INSTALLATION OF KITCHEN EXTRACTION SYSTEM AT
THE KINGS ARMS, THE GREEN, SHOULDHAM, PE33 0BY

PLANNING PERMISSION REF. NO. 22/00491/F

PLANNING APPLICATION FOR VARIATION OF PLANNING CONDITION 2

DRG. No.:- 1715.2

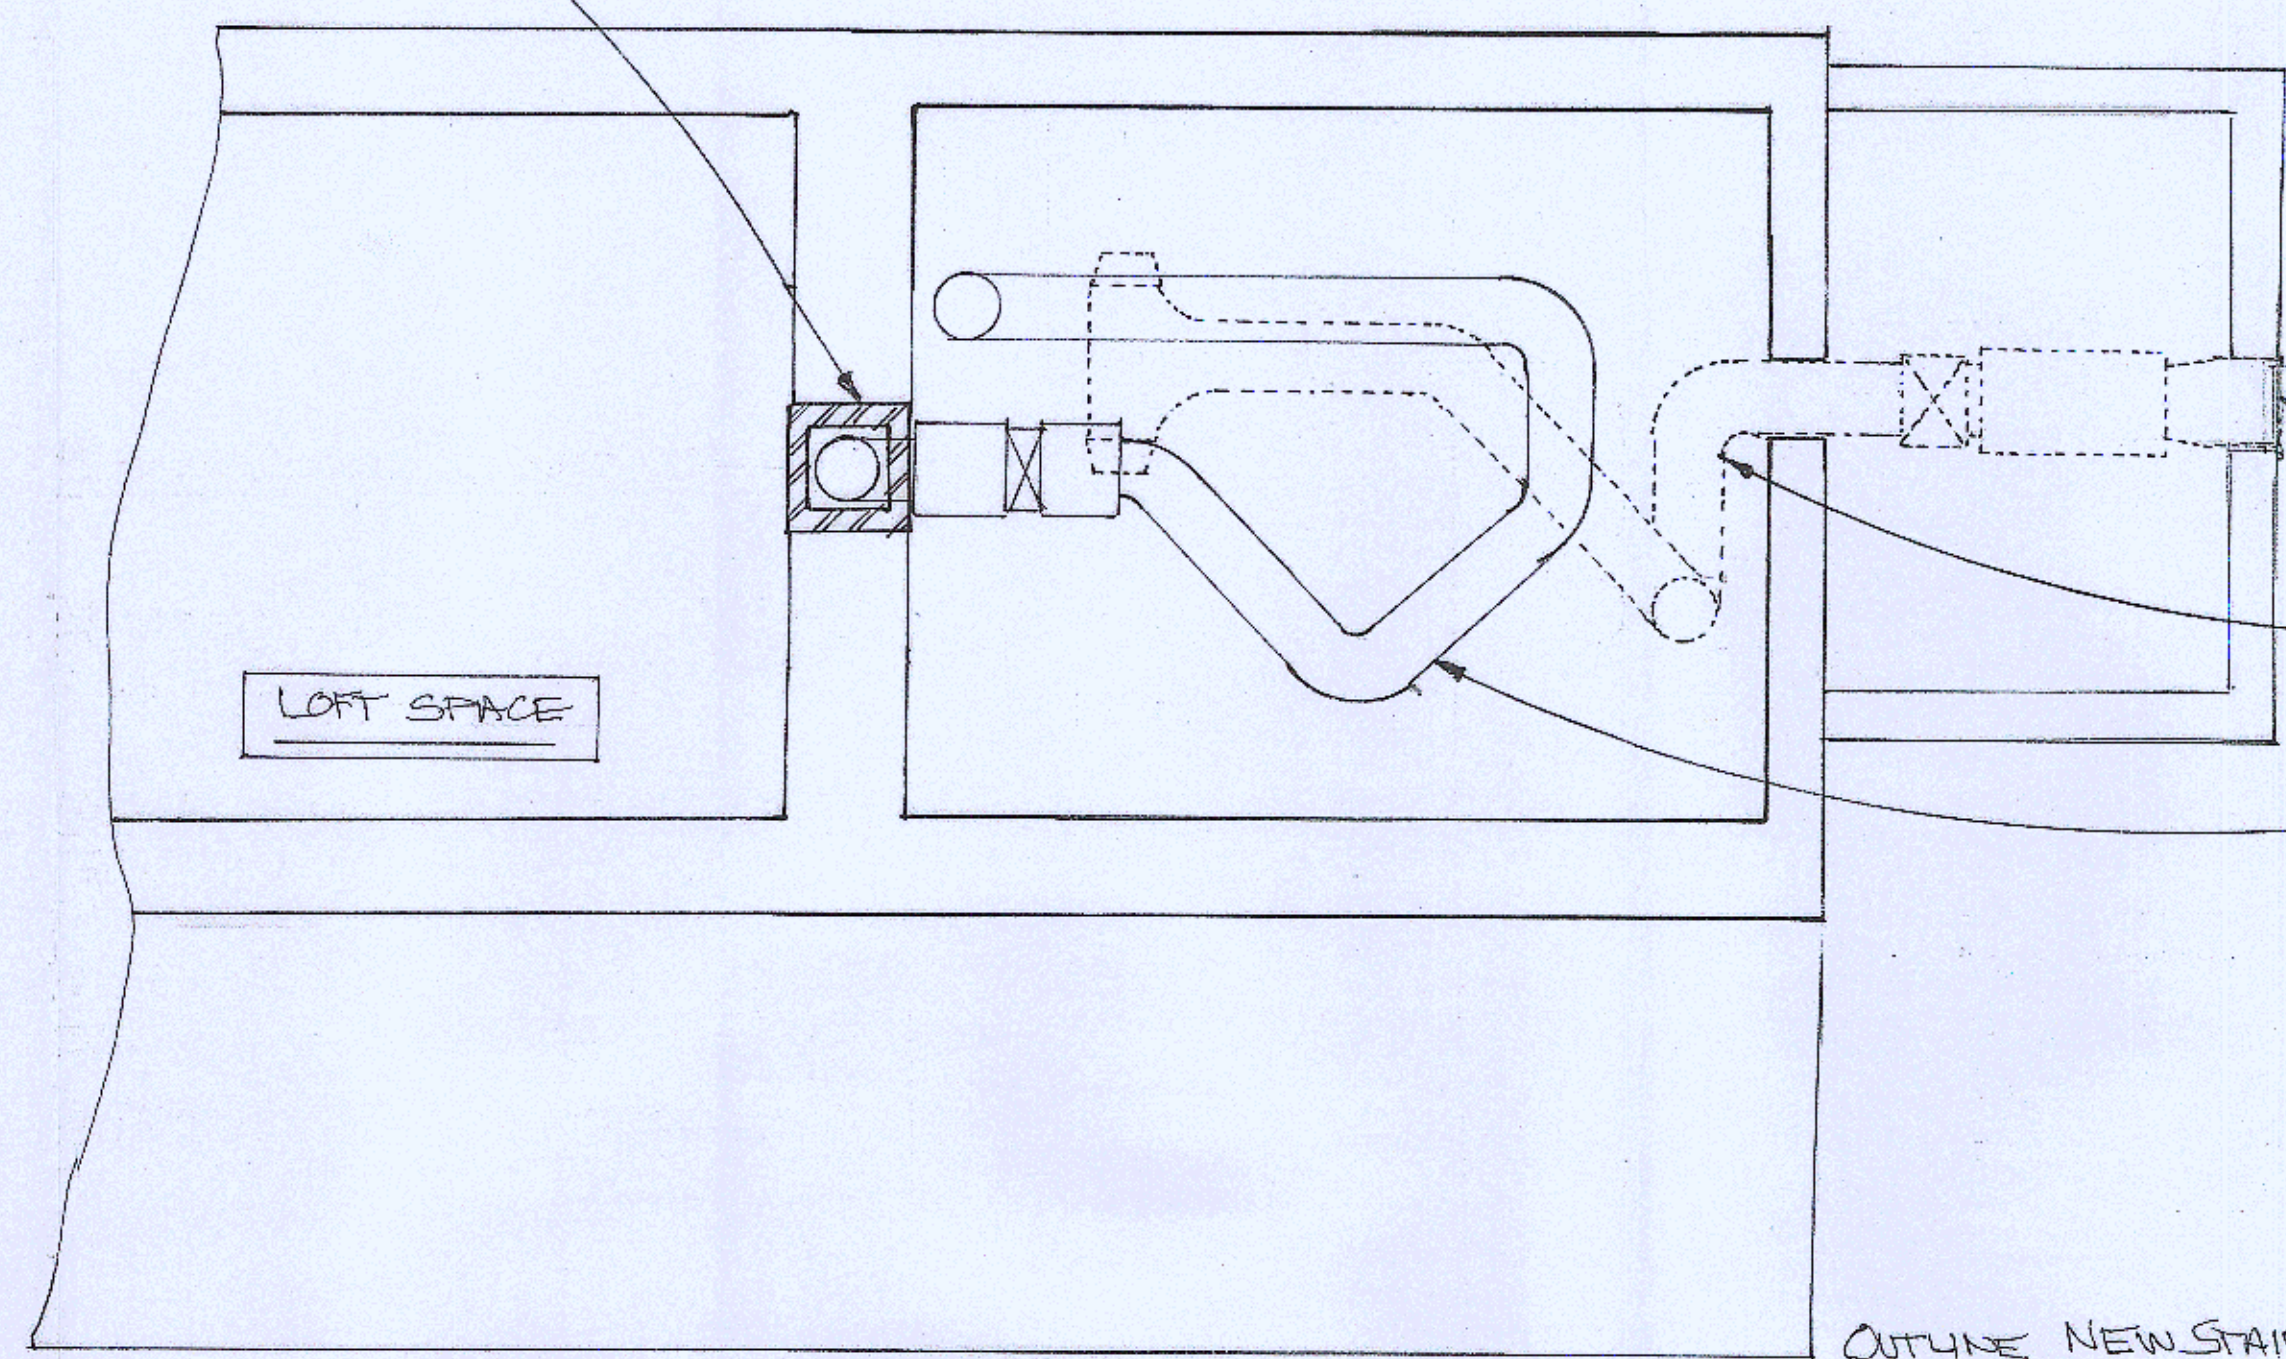
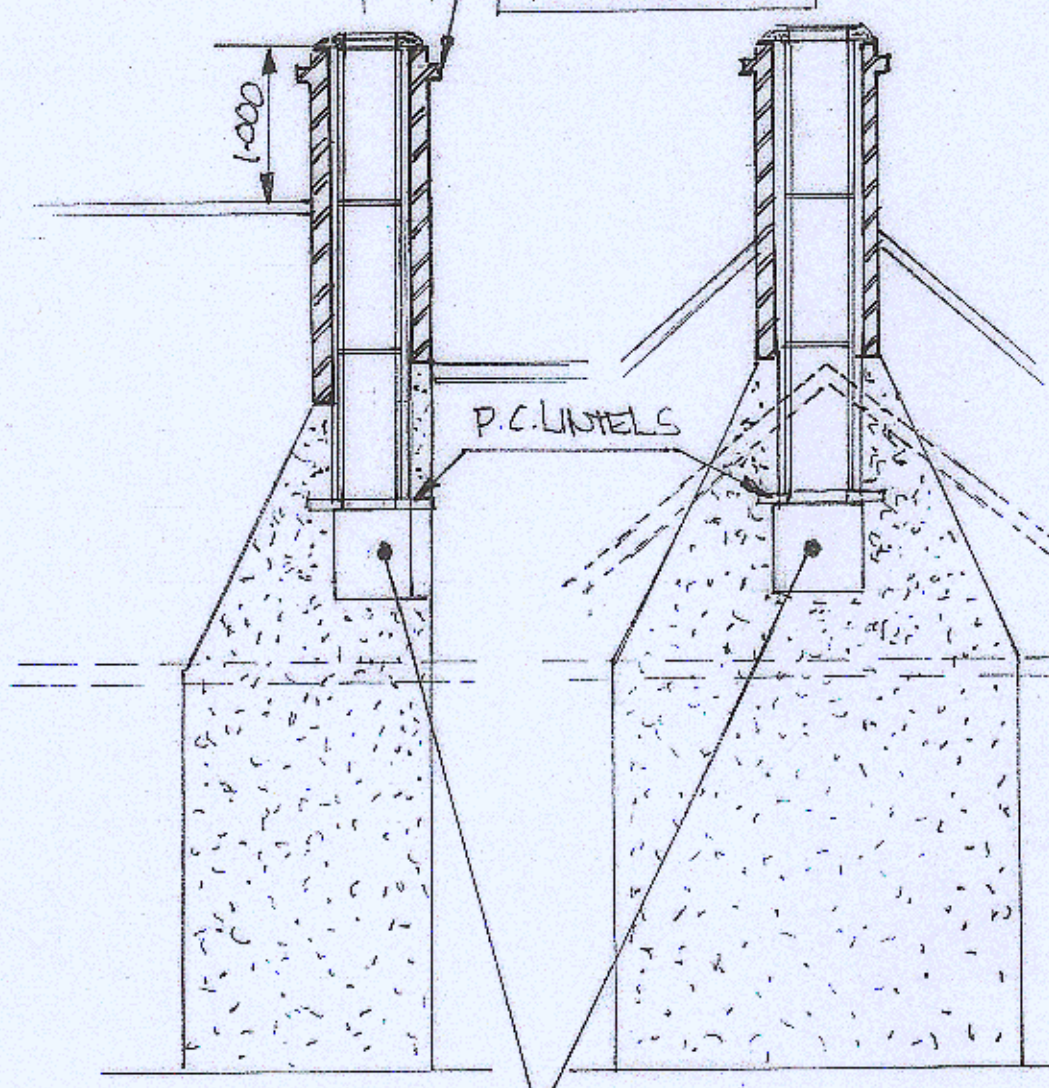
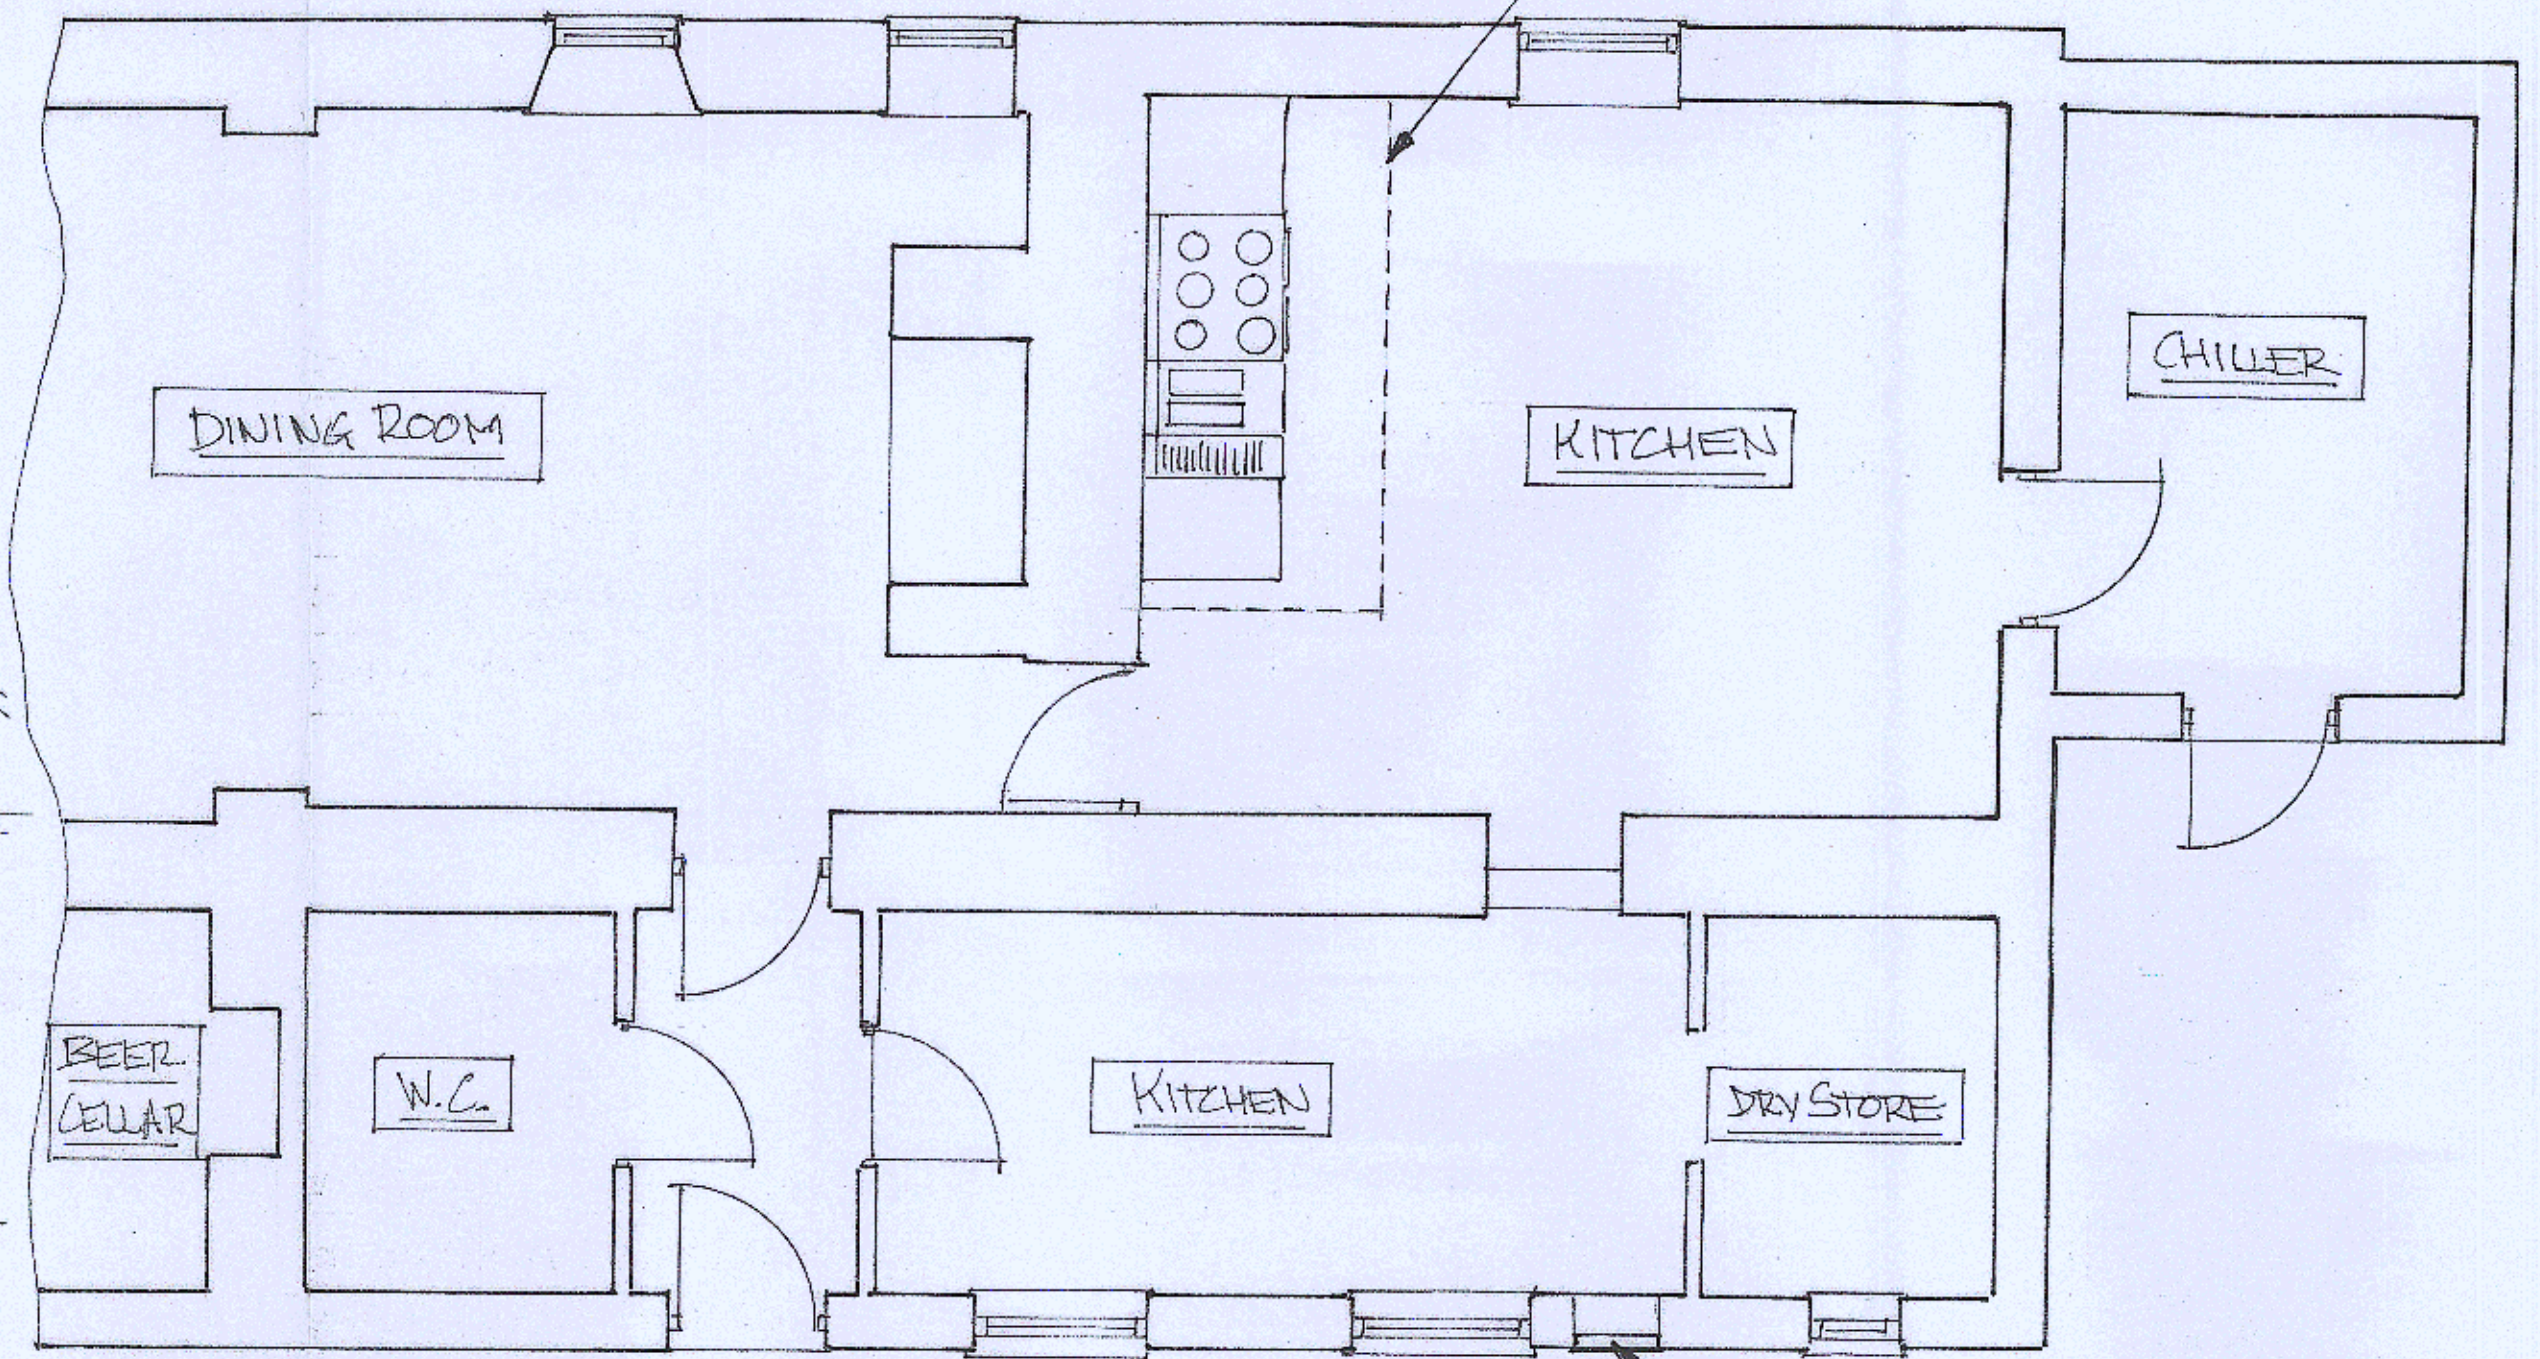
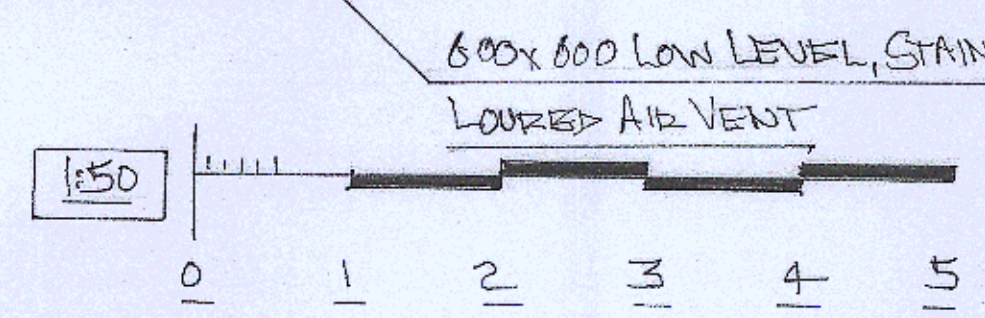
To retain the kitchen layout as it currently exists would require the re-design of the kitchen extraction and ventilation system. This matter was discussed at length with our designers C.K.Direct who confirmed that there was no technical reason why a re-designed systems should not be acceptable in terms of current legislation relating to commercial kitchen extraction and ventilation systems.

C.K.Direct have now completed their design work and specification, and as a result drawing number 1715.2 and C.K.Directs quotation/specification, both referred to in planning condition number 2 has been revised to reflect this re-design. Copies of drawing number 1715.2 - revised 12/01/2023, C.K.Directs up-dated quotation/specification together with C.K.Directs working drawing specification SWL 177120-DRG-001-R1 dated 11/01/23 are enclosed with this submitted planning application.

It is significant to note that the components of the kitchen extraction and ventilation system considered necessary to mitigate against emission of odour and noise have not changed. The revised plans include grease separators within the cooker hood, an extraction rate of 0.92m³/s velocity, a make up air system with a deign flow of 0.78m³.s, 2 no. trioxygen injectors, fans and silencers of the same specification of the currently approved plans. Other than the re-design of the route of the extraction and ventilation systems, the only other change from what has already been approved is the addition of a fan and associated silencer to provide the make up air.

Revisions to drawing number 1715.2 - kitchen extraction and ventilation system
